County Final/

Subject. Bill Mundy Project Application #[SE-21-00031

February. 3 2022. Follow up.

MUNDY/HILL PROPERTIES
 BILL MUNDY
 STA:10+00 TO STA:25+00
 FLYING M RANCH DRIVE PLAN & PROFILE

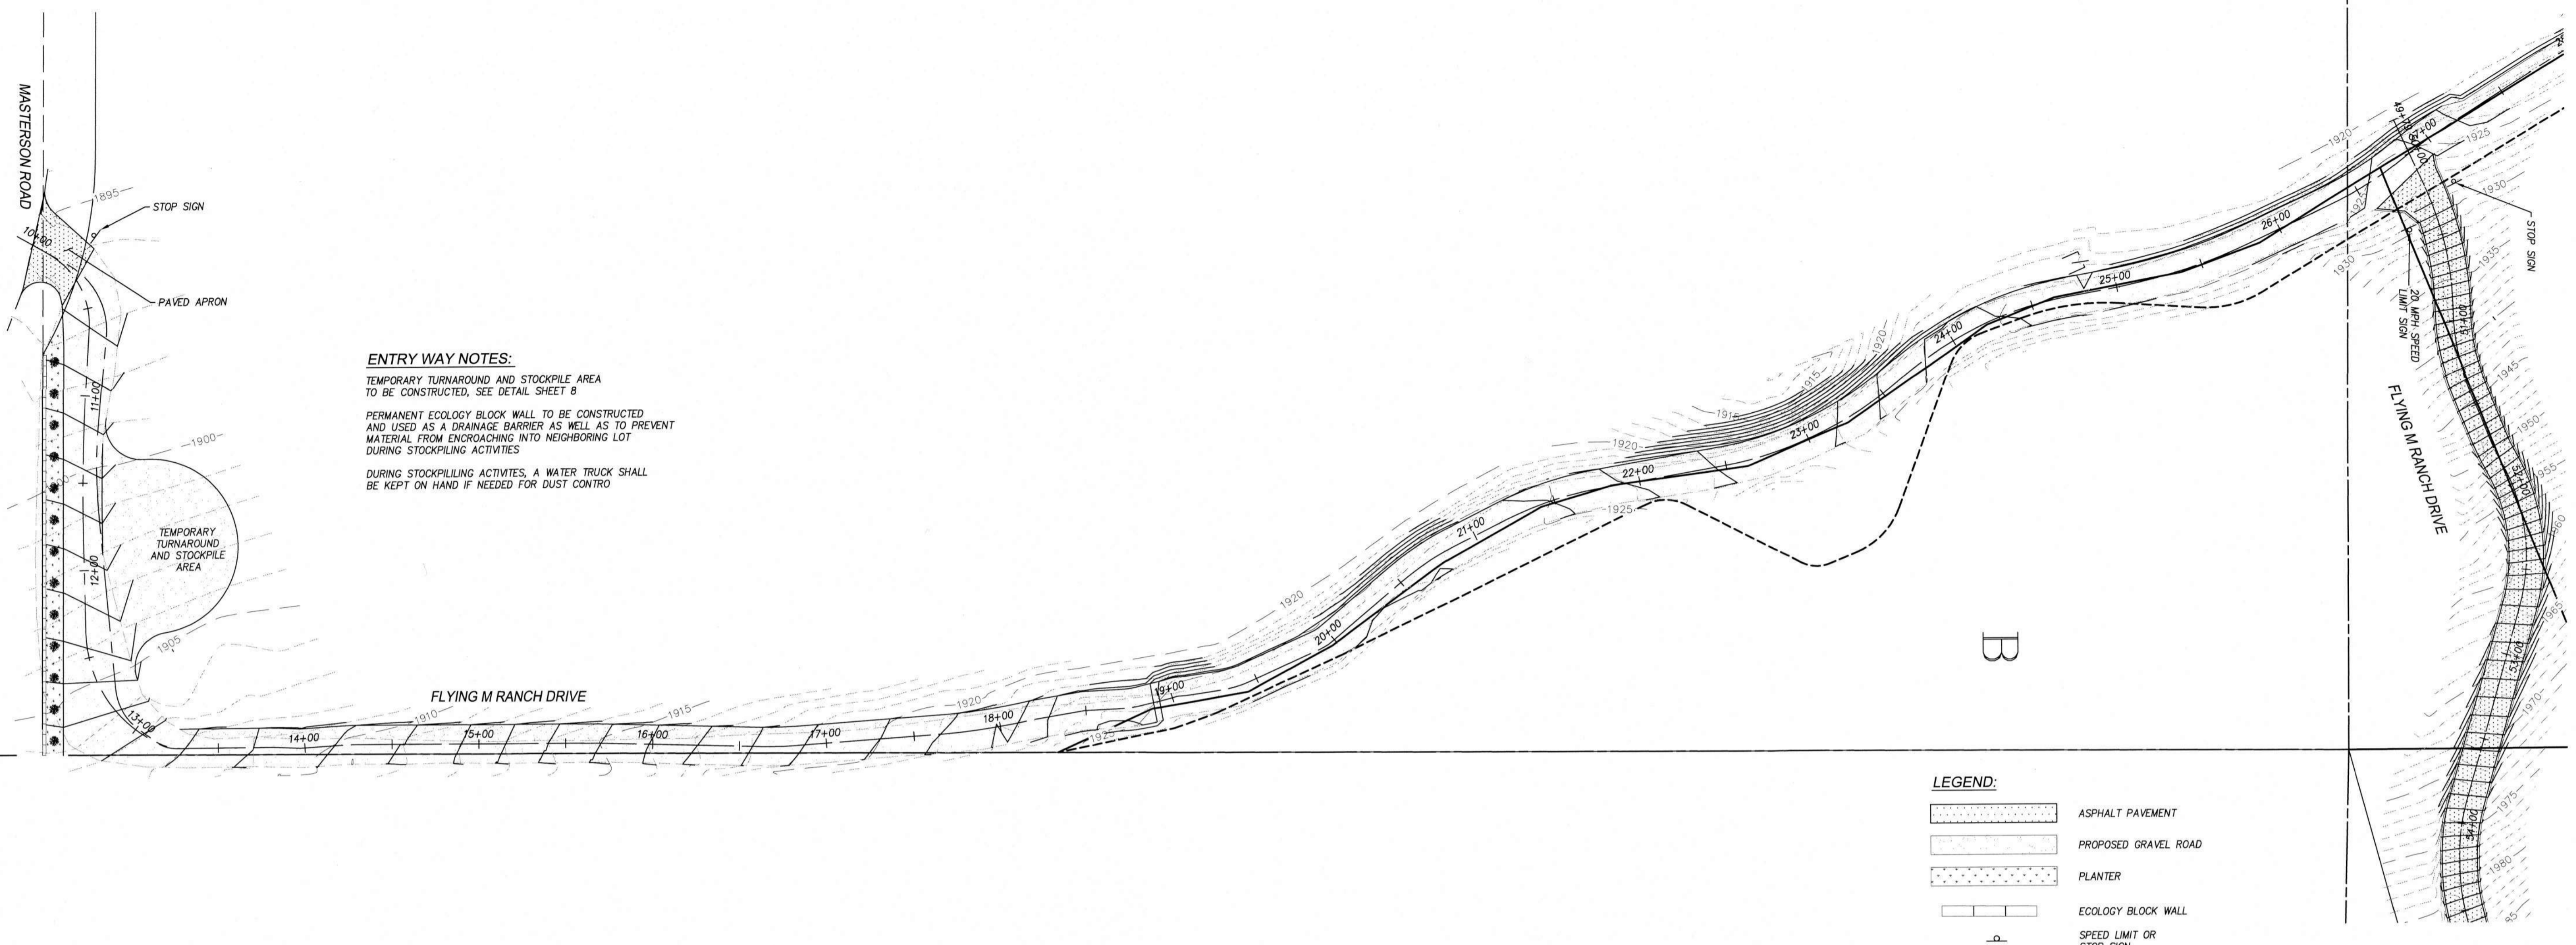
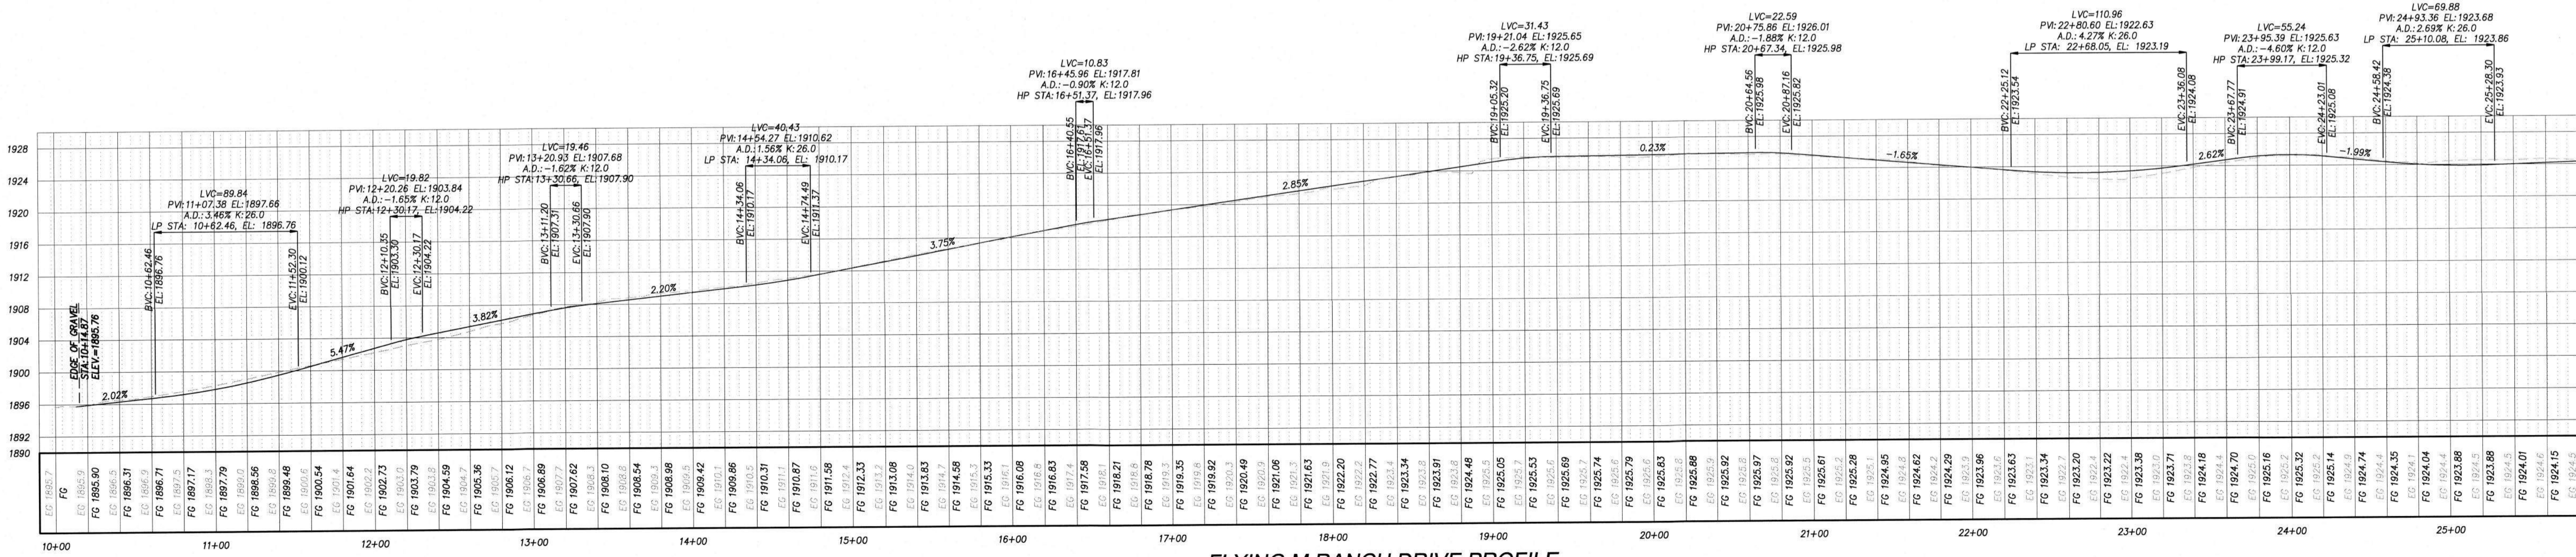
Finely, any attempt to place toxic, porous. Silica surplus concrete ecology blocks for any perpose, on my fence line, as Mr Mundy has stated, and right beside and on top of my home well, should be at once confronted by the Kittitas County. They have the responsibility to protect our water and air from just this kind of act. Washington statutes allow courts to enjoin the construction of any structure built maliciously and intended to spite, injure, or annoy an adjoining landowner.
